RE: Response to Second Submittal Comments – Falcon Meadows at Bent Grass Drainage Channel

File No.: CDR-21-14

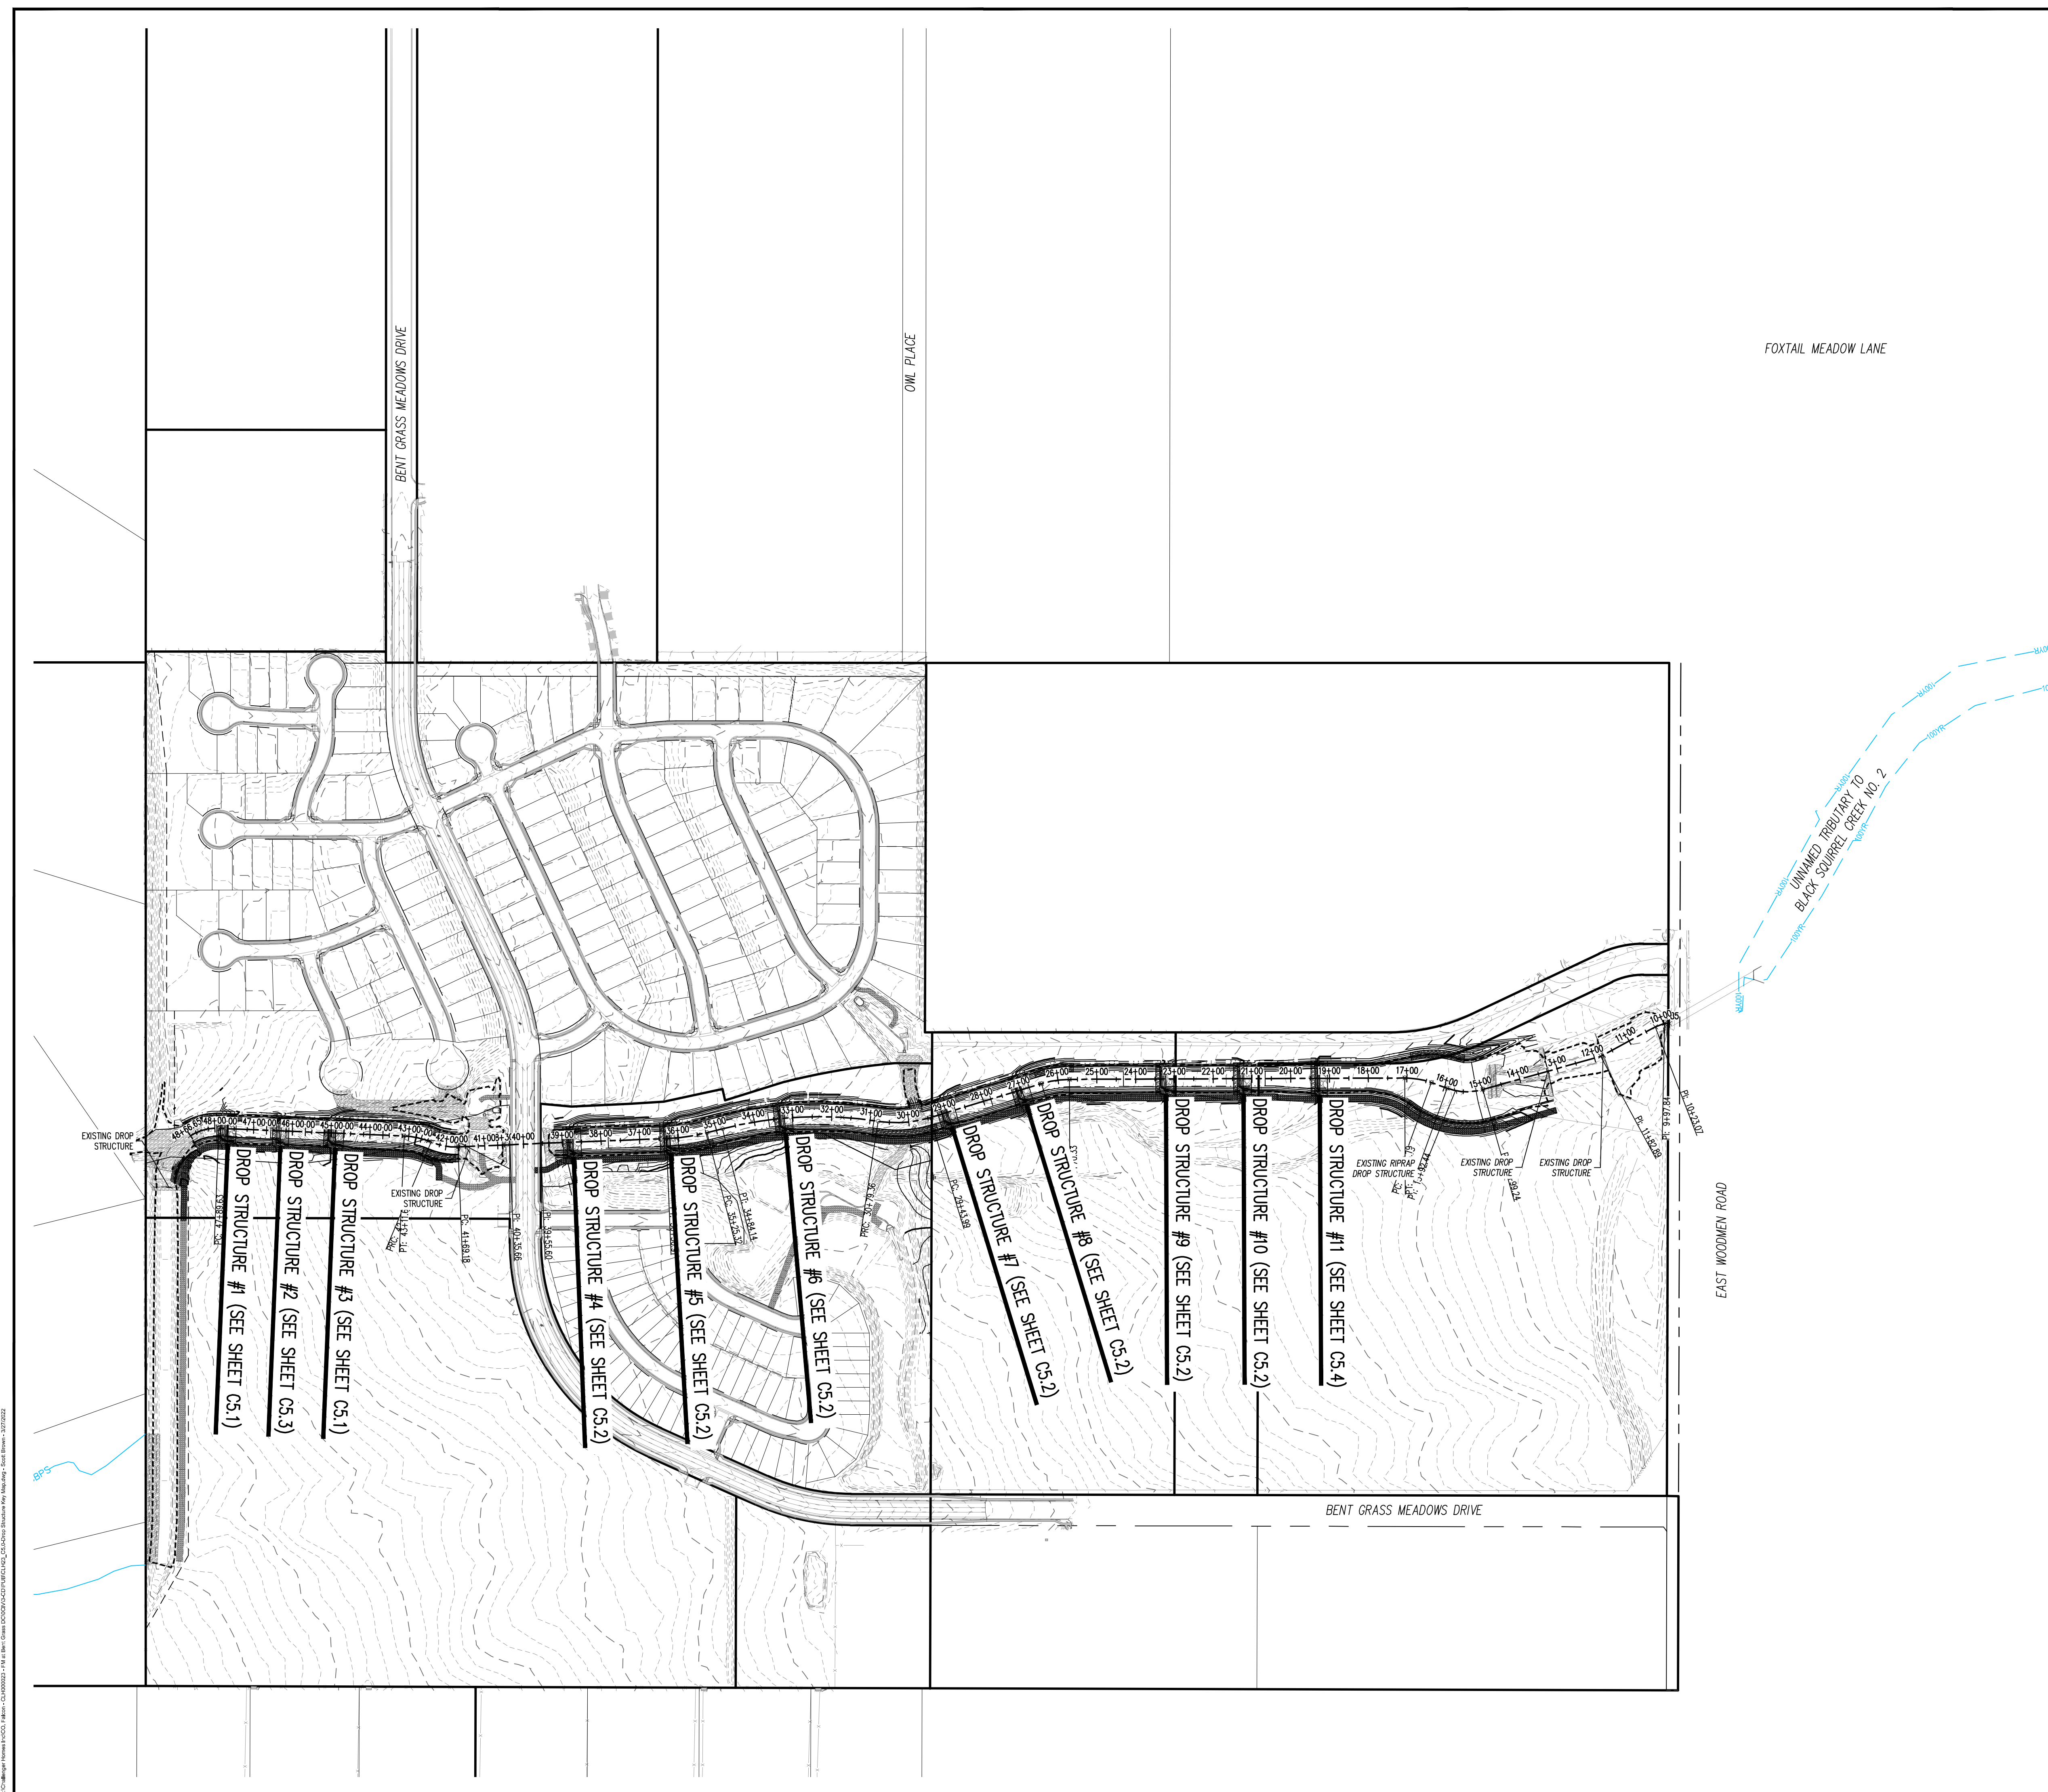
4. **Berms/dikes need to be removed and if fill is added to contain the floodplain it needs to be graded out to an even surface from the edge of the channel.**

Response: Grading has been revised accordingly.
